SSD8606 - RESPONSE TO SUBMISSIONS - LOT 23 & 24 HOLLINSWORTH ROAD, MARSDEN PARK

This Response to Submissions (RtS) provides responses to the agency and community submissions received during the public exhibition of the Environmental Impact Statement (EIS) for a warehousing and distribution estate at Lot 23 and 24, Hollinsworth Road, Marsden Park (SSD 8606).

2 21 Jun - 12pm
1 : 2000

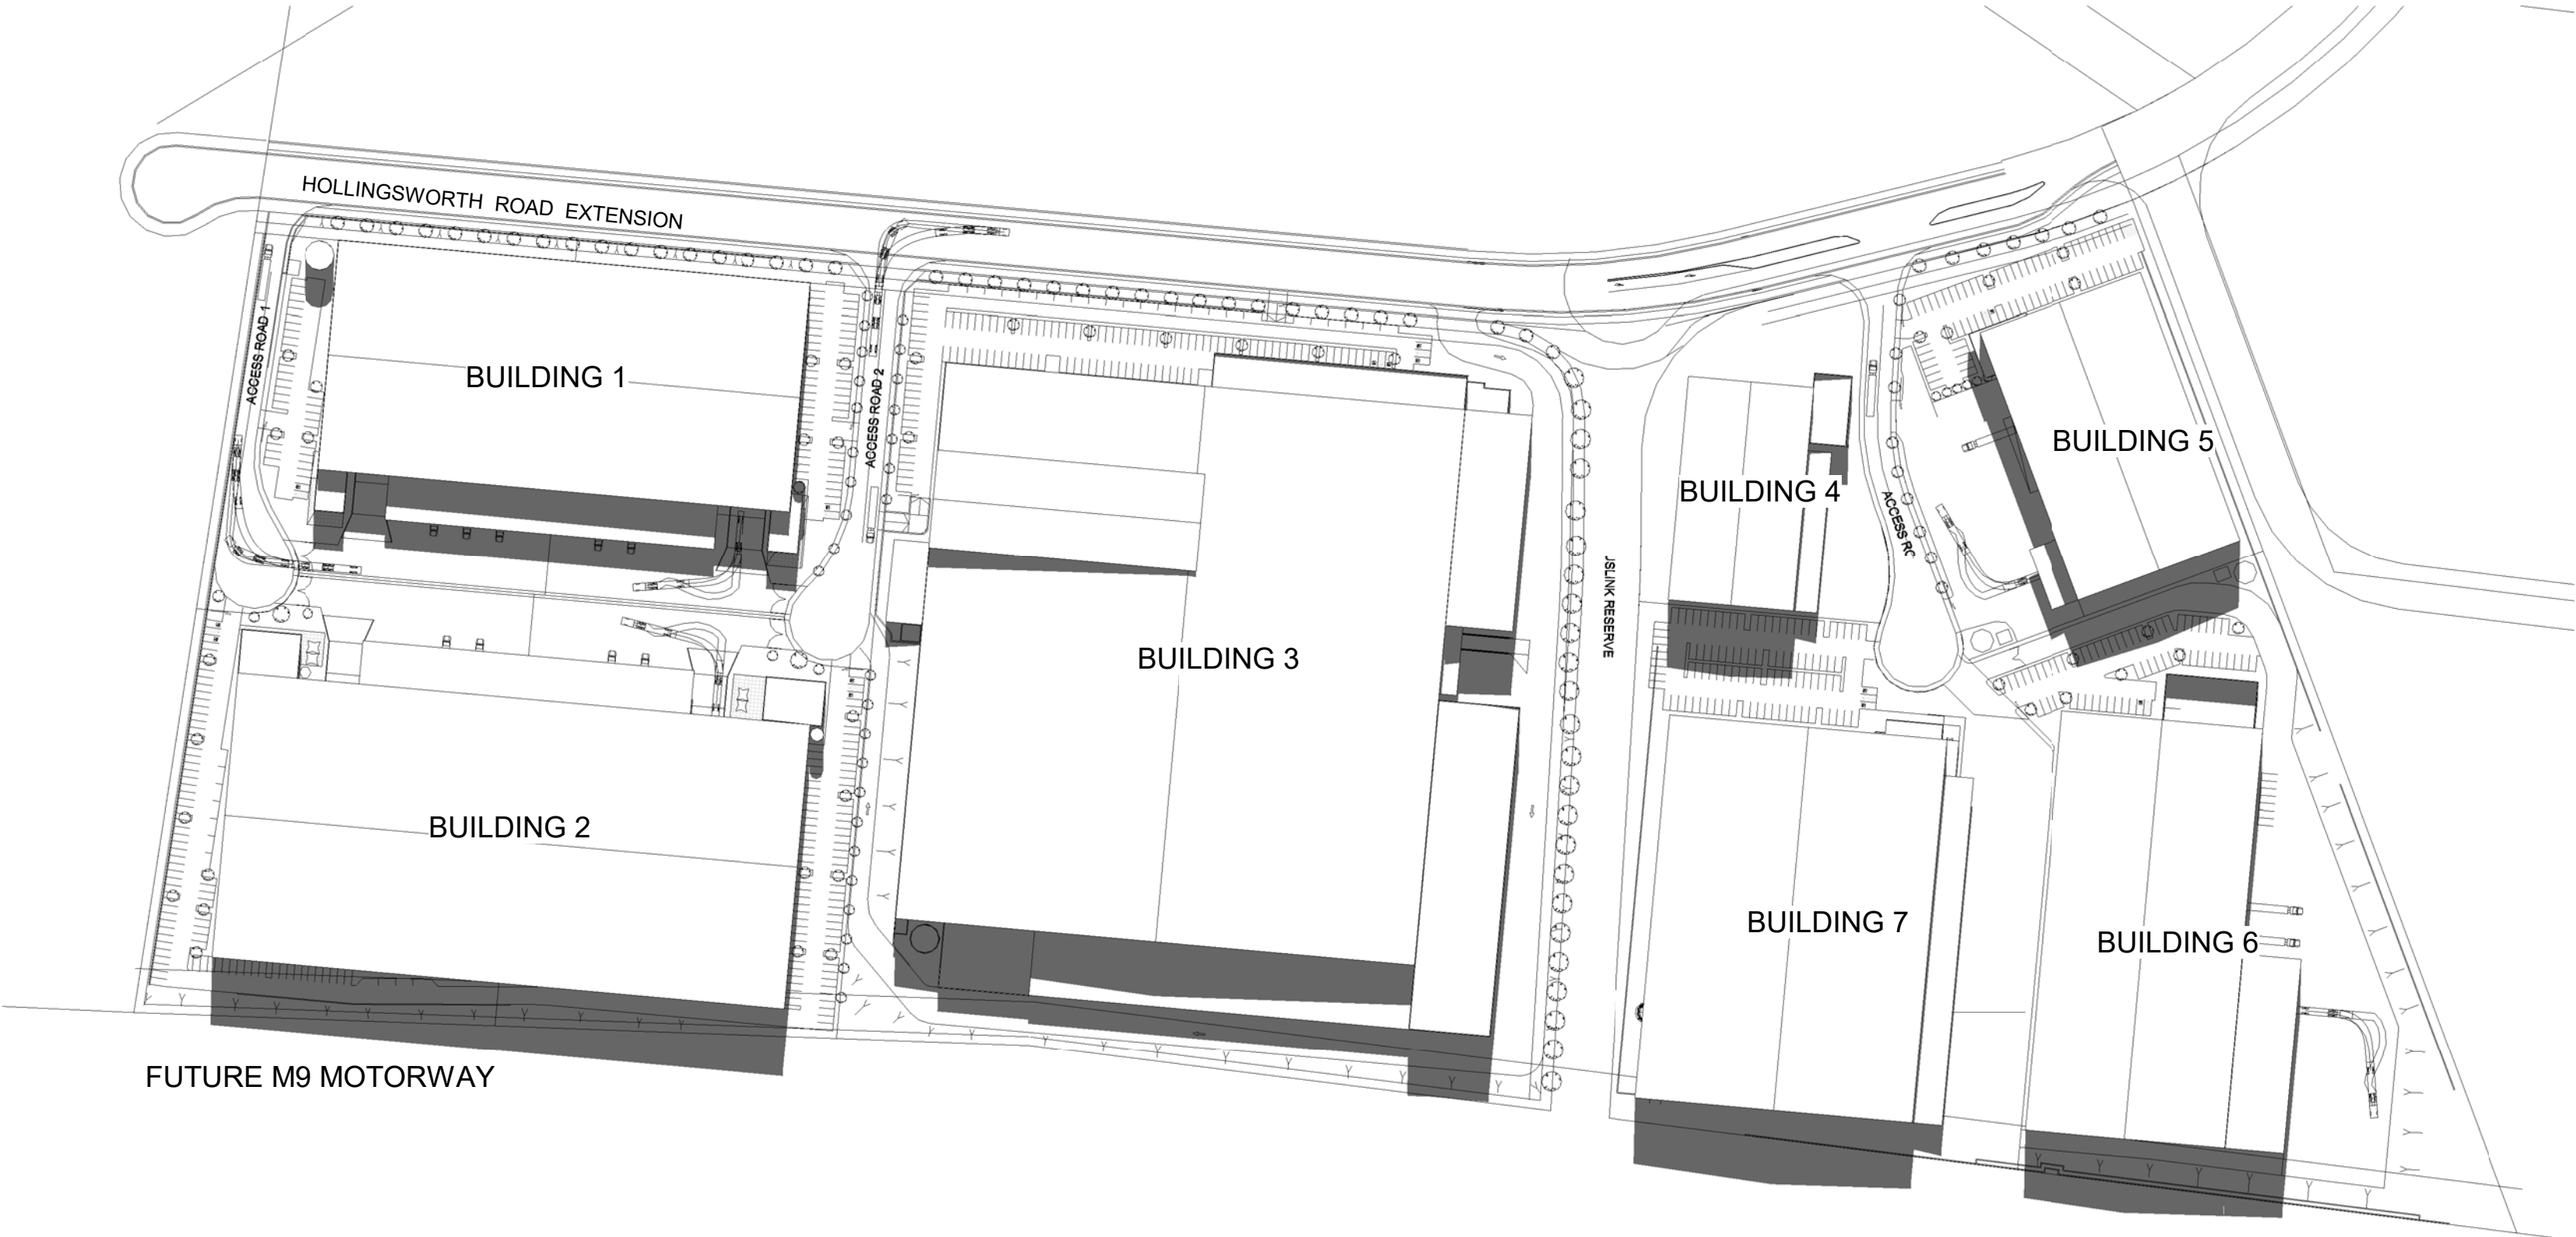
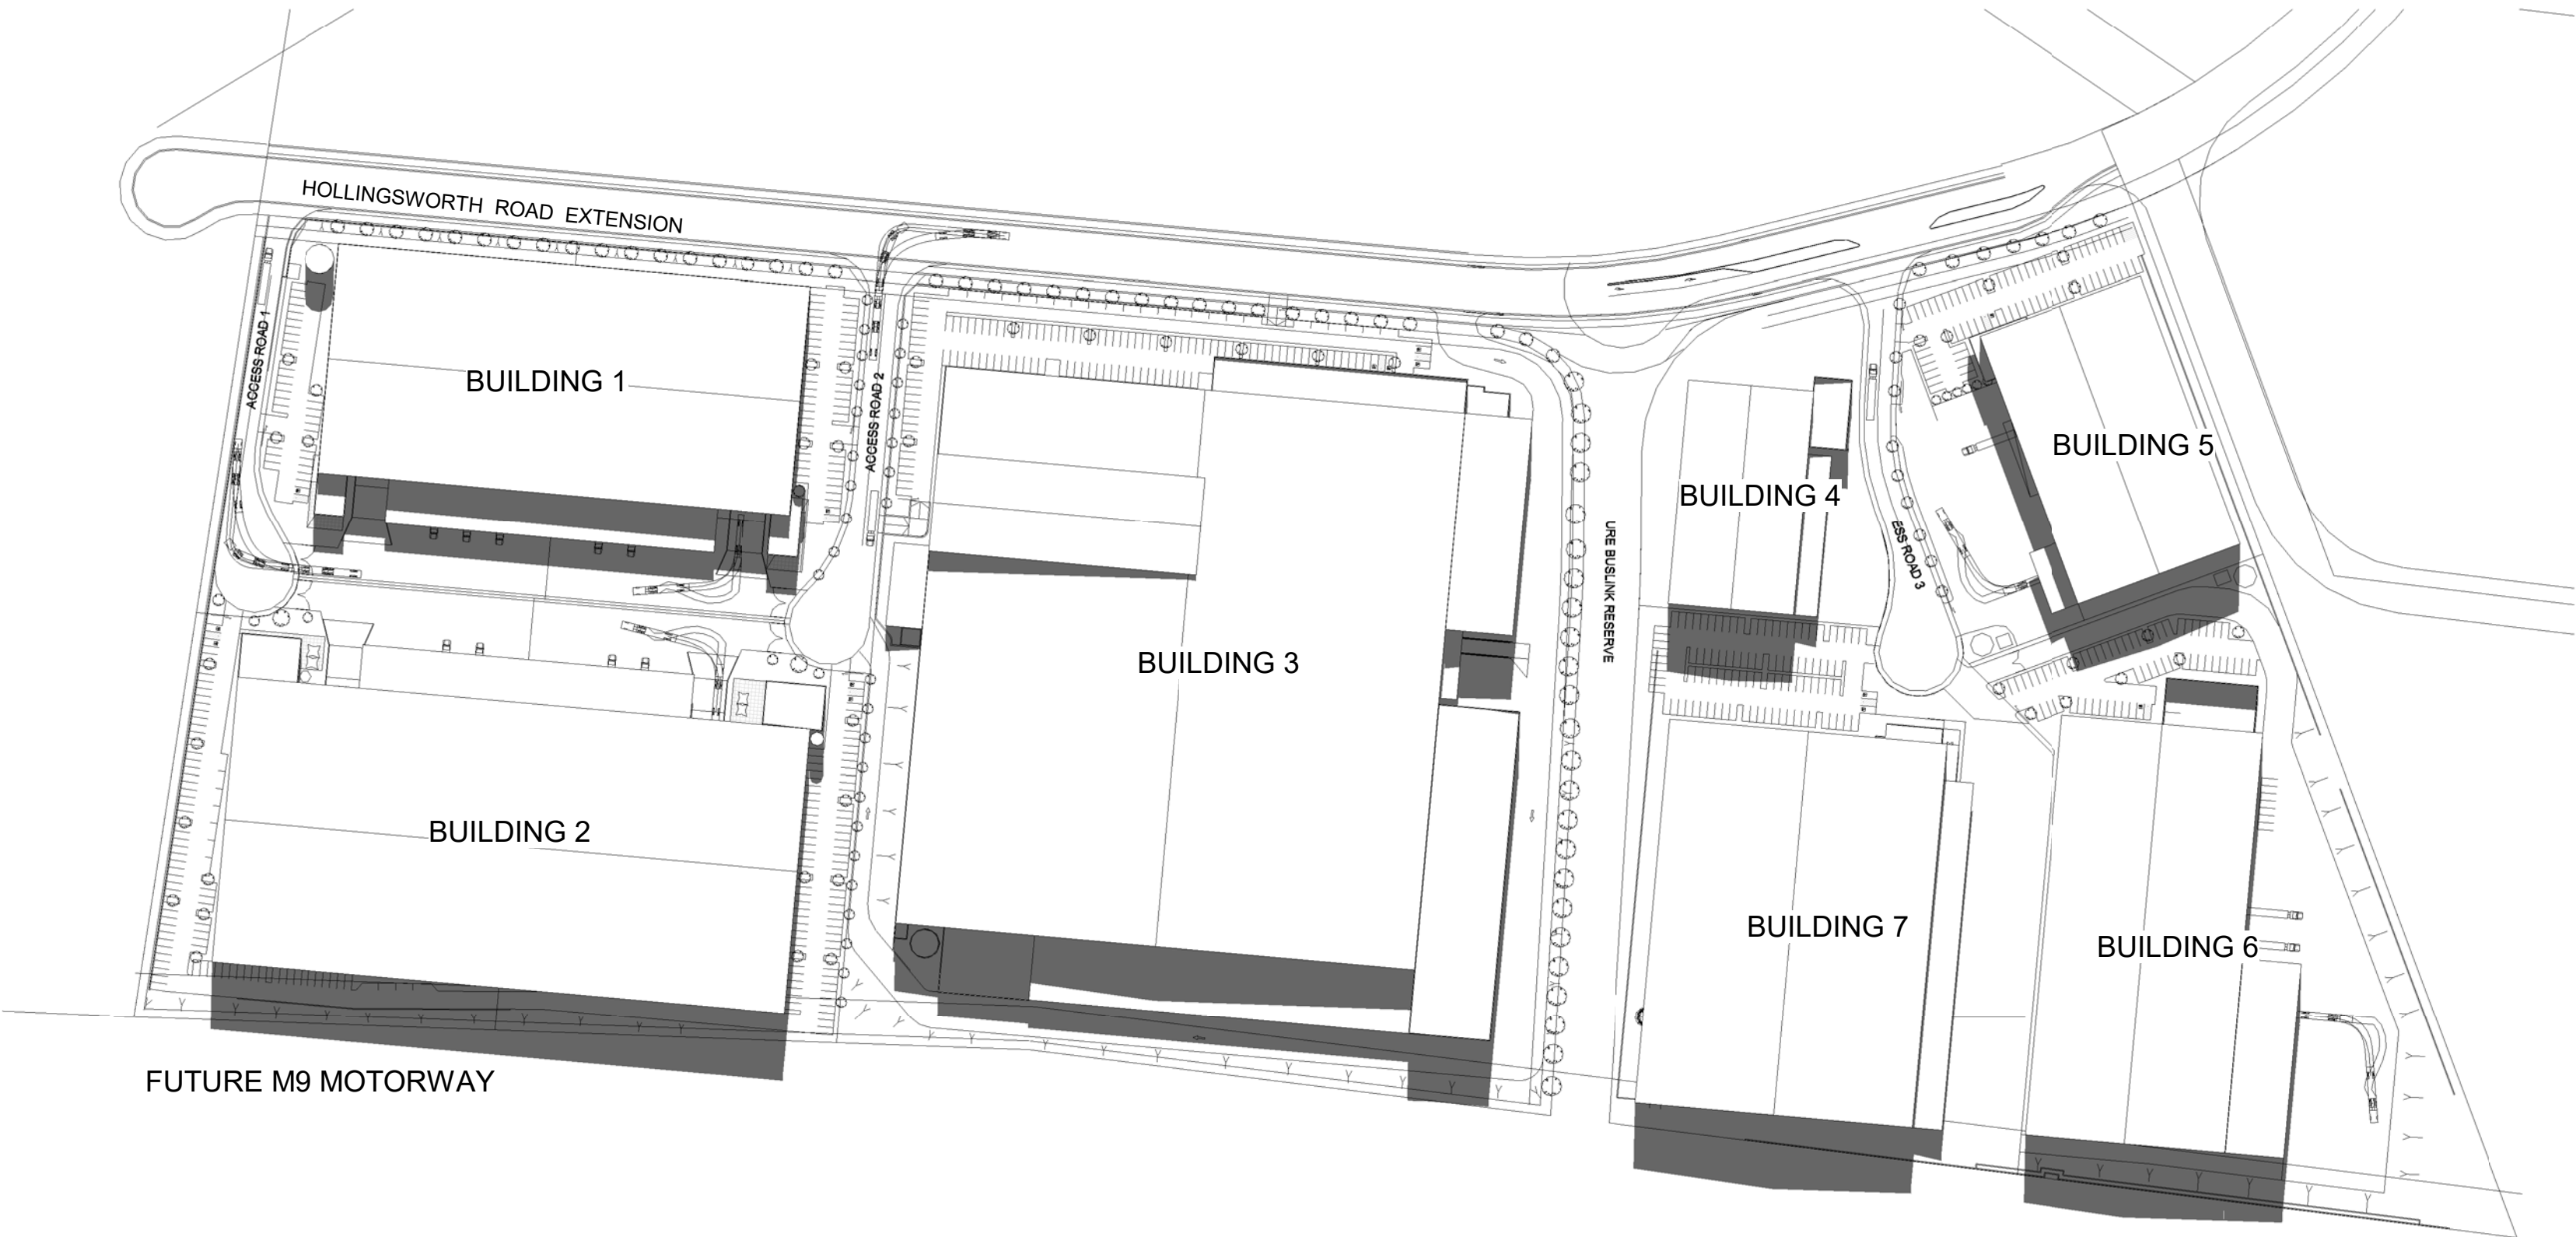
| Item Raised | Proponent's Response |
|-------------------------------------------------------------------------------------------------------------------------------------------------------------------------------------------------------------------|---------------------------------------------------------------------------------------------------------------------------------------------------------------------------------------------------------------------------------------------------------------------------------------------------------------------------------------------------------------------------------------------------------------|
| A shadow diagram should be provided. | Shadow diagrams have been prepared to show shadows at 9am, 12pm and 3pm on 21 December and 21 June. |

| Item Raised | Proponent's Response |
|--------------------------------------------------------------------------------------------------------------------------------------------------------------------------------------------------------------------------------------------------|--------------------------------------------------------------------------------------------------------------------------------------------------------------------------------------------------------------------------------------------------------------|
| | <p>No detrimental shadow impact is generated by the proposal, given the separation distances between the site and the public domain / residential receivers.</p> <p>Refer to drawings LG-MAR-S1 and LG-MAR-S2.</p> |
